**Subject: HVO North and South Open Cut Coal Continuation Project (SSD-11826681 and SSD-11826621) (Singleton Shire)**

## Attachment 1 - CPHR Comments

### HVO North and South Open Cut Coal Continuation Project

Figure 7 – River Red Gum restoration areas

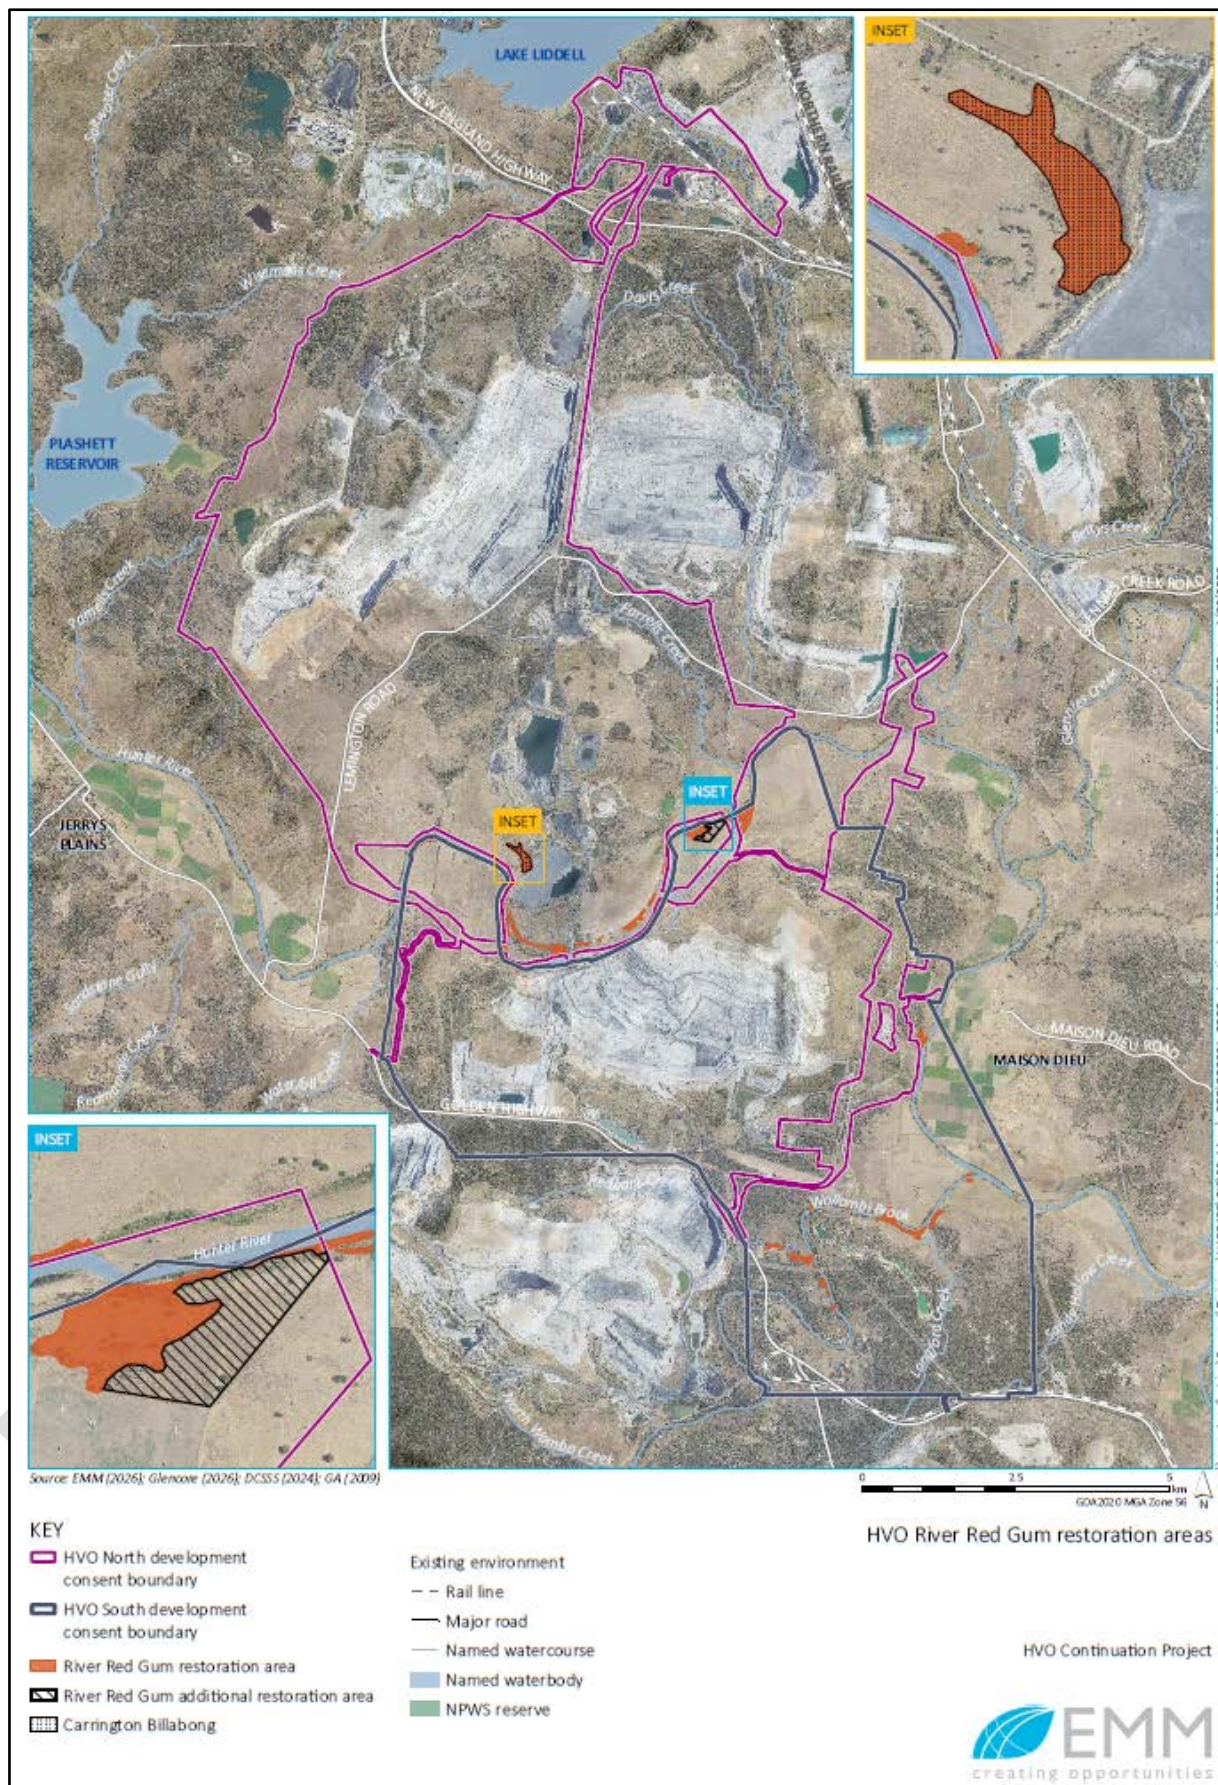
|   | <p>areas. It is currently unclear whether proposed offset or rehabilitation areas within this proposal overlap with those that have been previously committed to.</p> <p>For example, the BDAR proposes 6.6ha be set aside as part of the proposed 'Hunter Floodplain Red Gum Woodland Restoration Area'. However, it is unclear whether this area has already been committed to be offset under a previous consent.</p>                                         |                                                                                                                                                                                                                                                                                                                                                                                                                                                                                                                                                                                                                                                                                                                                                                                                                                                                                                                                                                      |                                                  |
| 4 | <p>CPHR supports the inclusion of 6.6ha of land entering into conservation, however, considers that the current River Red Gum Rehabilitation and Restoration Strategy (RRGRRS) does not reflect best practice management methods that reflect the current onsite conditions.</p> <p>Findings from the recent HVO RRGRRS assessment (HVO, August 2025) indicate that rehabilitation within the existing protected areas has not been demonstrably successful.</p> | <p>CPHR recommends that any approval include consent conditions requiring the preparation of an updated RRGRRS, to include the additional 6.6ha and provide improvements to the plan to ensure that positive and measurable environmental outcomes can be achieved.</p> <p>CPHR requests that the revised RRGRRS be developed in consultation with, and to the satisfaction of, CPHR to ensure its adequacy.</p>                                                                                                                                                                                                                                                                                                                                                                                                                                                                                                                                                     | To be conditioned prior to commencement of works |

| No | Comments                                                                                                                                                                                                                                                                                                                                                                                                           | Recommendation                                                                                                                                                                                                                                            | Timing                                            |
|----|--------------------------------------------------------------------------------------------------------------------------------------------------------------------------------------------------------------------------------------------------------------------------------------------------------------------------------------------------------------------------------------------------------------------|-----------------------------------------------------------------------------------------------------------------------------------------------------------------------------------------------------------------------------------------------------------|---------------------------------------------------|
| 2  | It is recommended that the BDAR identify previous commitments to offset or rehabilitate the subject land. The BDAR should demonstrate that the proposed activity does not impact upon these                                                                                                                                                                                                                        | CPHR recommends that all previous offset / rehabilitation areas associated with Hunter Valley Operations be included and mapped within the BDAR to allow adequate assessment of avoidance and ensure no double dipping has occurred.                      | Prior to approval                                 |
